KIRKLEES METROPOLITAN COUNCIL INVESTMENT & REGENERATION SERVICE

Reference No:	2023/62/92431/W
Site Address:	17, Rafborn Avenue, Salendine Nook, Huddersfield, HD3 3UJ
Description:	Erection of single storey rear extension and alterations
Recommending Officer:	Laura Yeadon

HOUSEHOLDER DELEGATED REPORT

Application Number	2023/92431
Location	17, Rafborn Avenue, Salendine Nook, Huddersfield, HD3 3UJ
Proposal	Erection of single storey rear extension and alterations
Publicity end date	26 th September 2023* amended plans not re-publicised as these reduced the scale of development
Number of representations received	None
Kirklees Local Plan Allocation/Designation	Unallocated – without notation within the Kirklees Local Plan
Extension to Time (EoT)	No EoT Date:
Recommendation	Conditional Full Permission

Scale 1:100
date 08/2023
sheet size A1
dwg. no. 23/919/04b

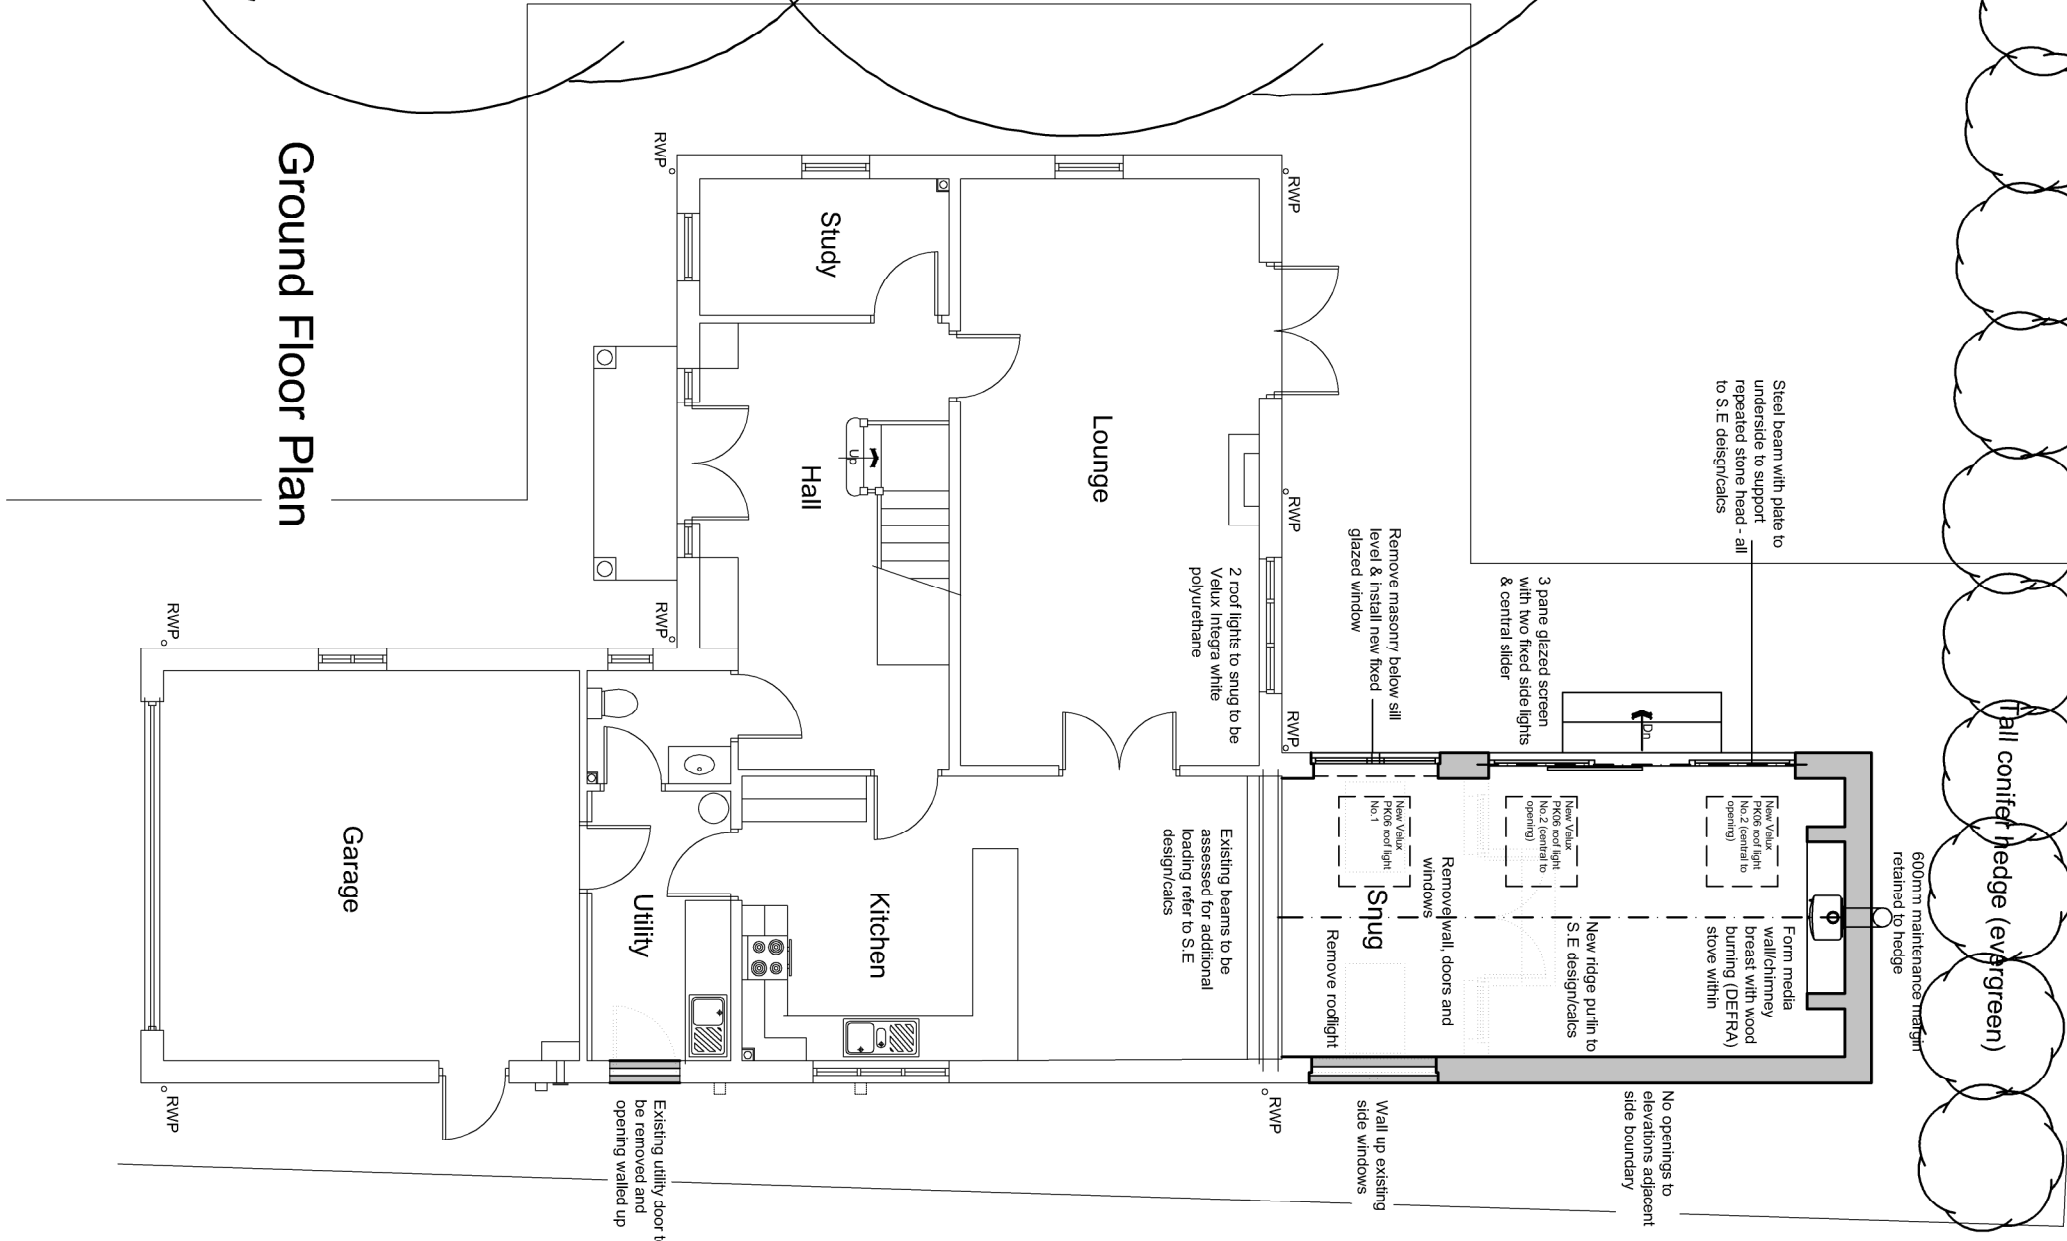
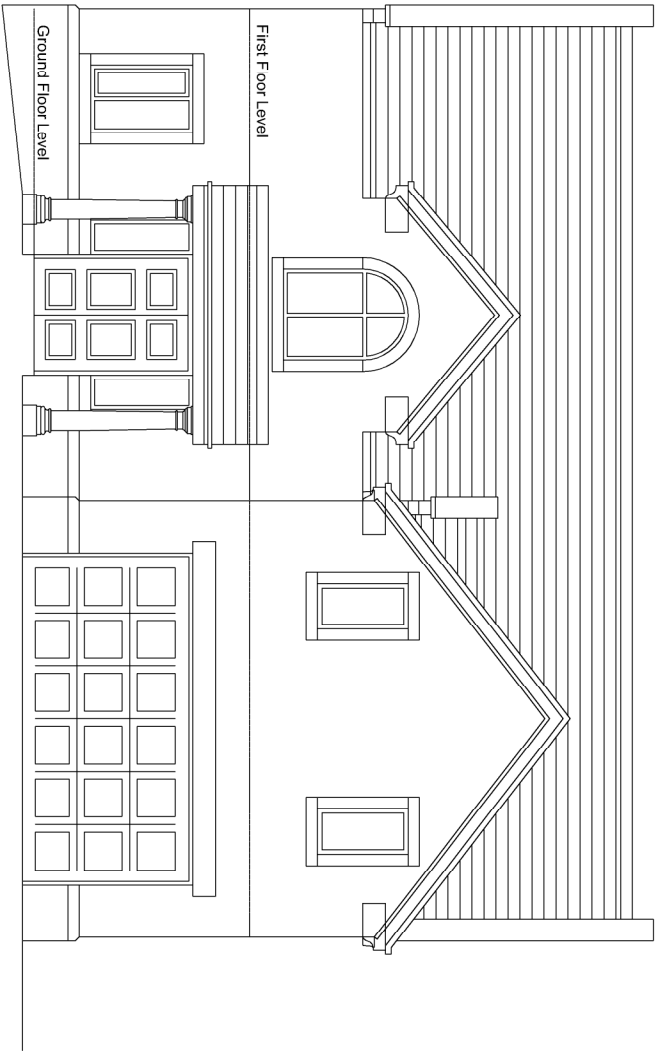
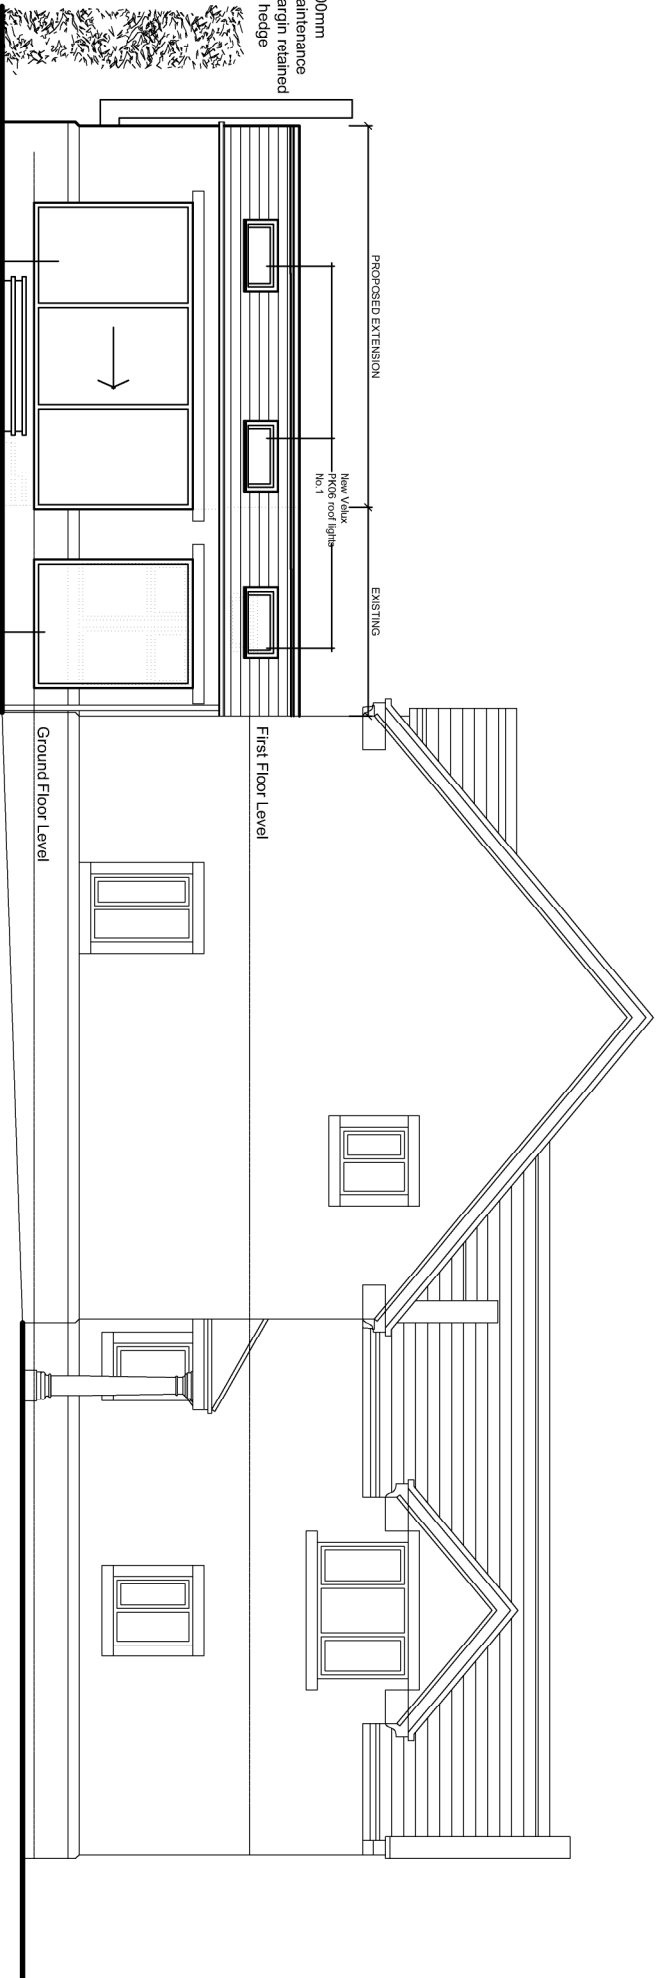
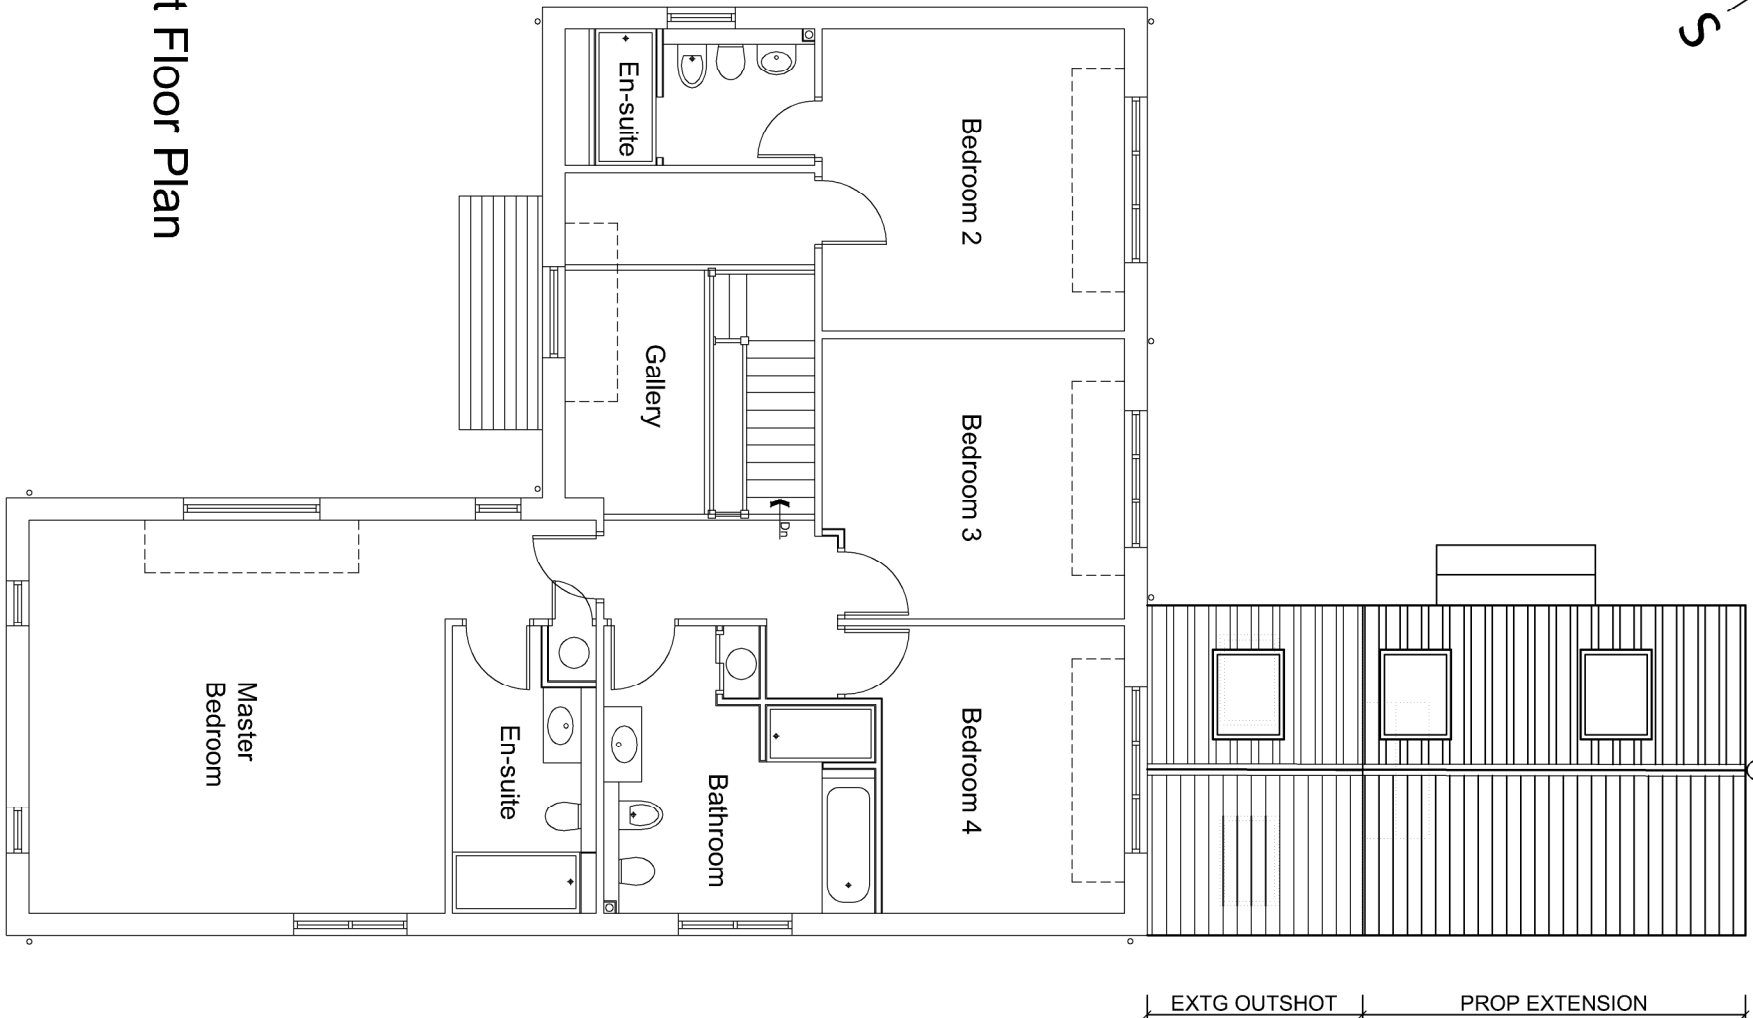
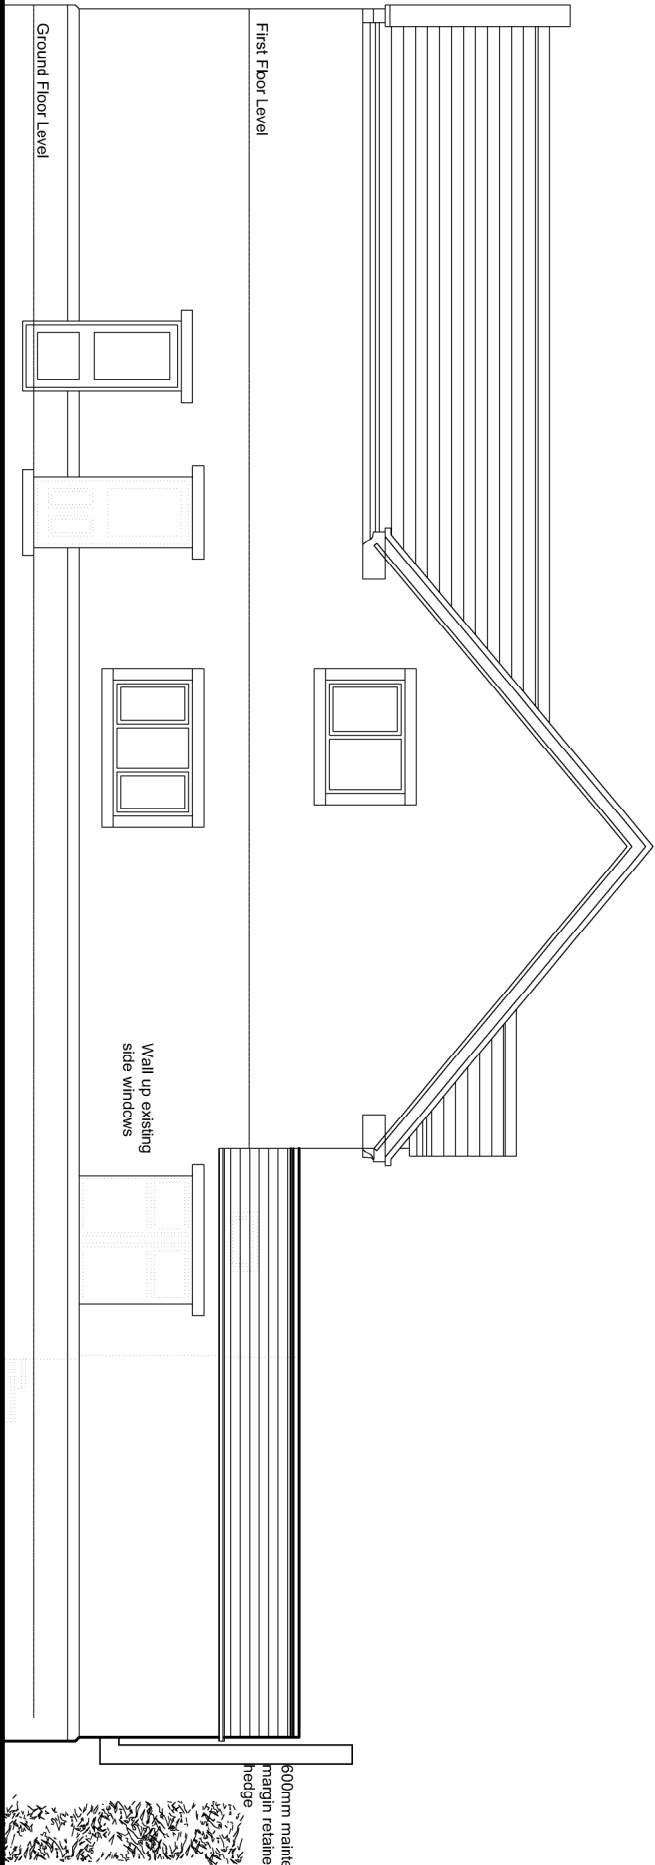
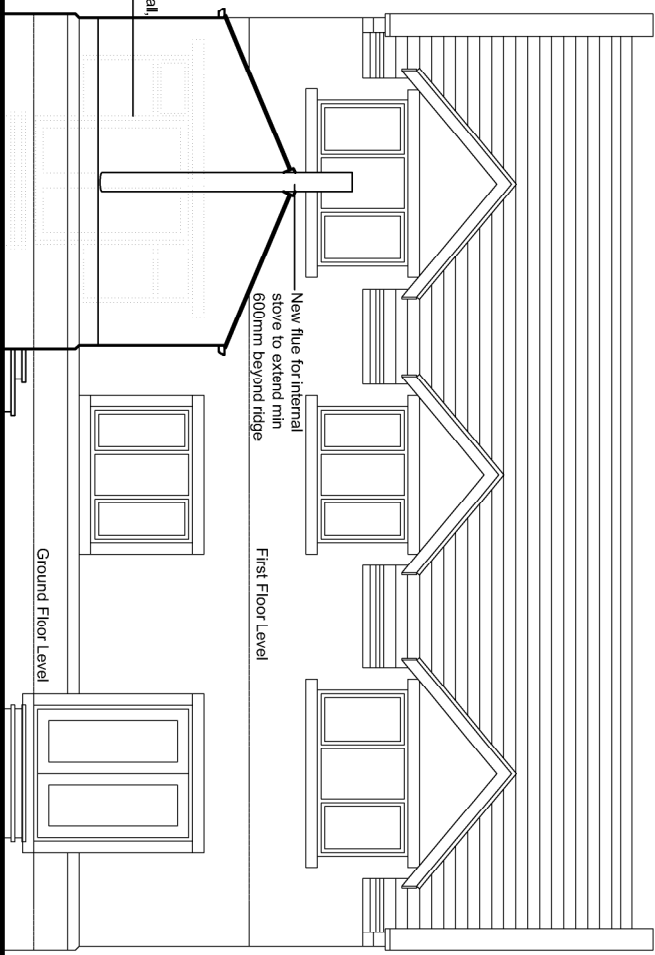
YES NO	SUMMARY
Negotiations/Amendments during course of application	Yes	Following concerns with regards to the overall projection of the proposal on neighbouring properties the plans were amended to reduce the projection to 5 metres, with justification submitted for departing from the SPD. Amended plans were received on 25/10/2023 which also retained the existing hedge to the north-east boundary
Parish/Town Council comments sought	N/A

The application seeks permission for the erection of a single storey rear extension and alterations. The extension would be positioned to the rear of the property along the south-eastern boundary lying flush with the existing elevations incorporating the 'snug'. The extension would project 5 metres from the rear elevation of the 'snug' with the eaves and ridge height being a continuation of the existing. Construction materials would be to match.

Alterations are also proposed which includes the removal of the masonry below the existing 'snug' window on the north-west facing side elevation of the property to enable a full height opening to be inserted and also the utility room door would be walled up as would the existing opening within the side elevation on the south-eastern facing side elevation.

where they exceed 3m in length the eaves height should generally not exceed 2.5 meters		No – the extension would have an eaves height of 2.9 metres. Additional 0.4 metres is not considered to compromise the visual amenity of the structure

- 19 Rafborn Avenue – detached dwelling to the south-east of the application site – set on a slightly lower ground level with small lower ground floor openings within rear elevation – 45 degree line would not be met however as the extension is to the north of this neighbour there would be limited impact in terms of loss of direct sunlight – it is noted that this property has a rear terraced which is elevated above the ground level of the application site.

Pursuant to article 35 (2) of the Town and Country Planning (Development Management Procedure) Order 2015 and guidance in the National Planning Policy Framework, the Local Authority have, where possible, made a pre-application advice service available, complied with the Kirklees Development Management Charter 2015 and otherwise actively engaged with the applicant in dealing with the application. Concern were raised to the Agent regarding the proposed projection of the extension. Amended plans were received which reduced the projection from 6 metres to 5 metres and the hedge along the north-east boundary retained.
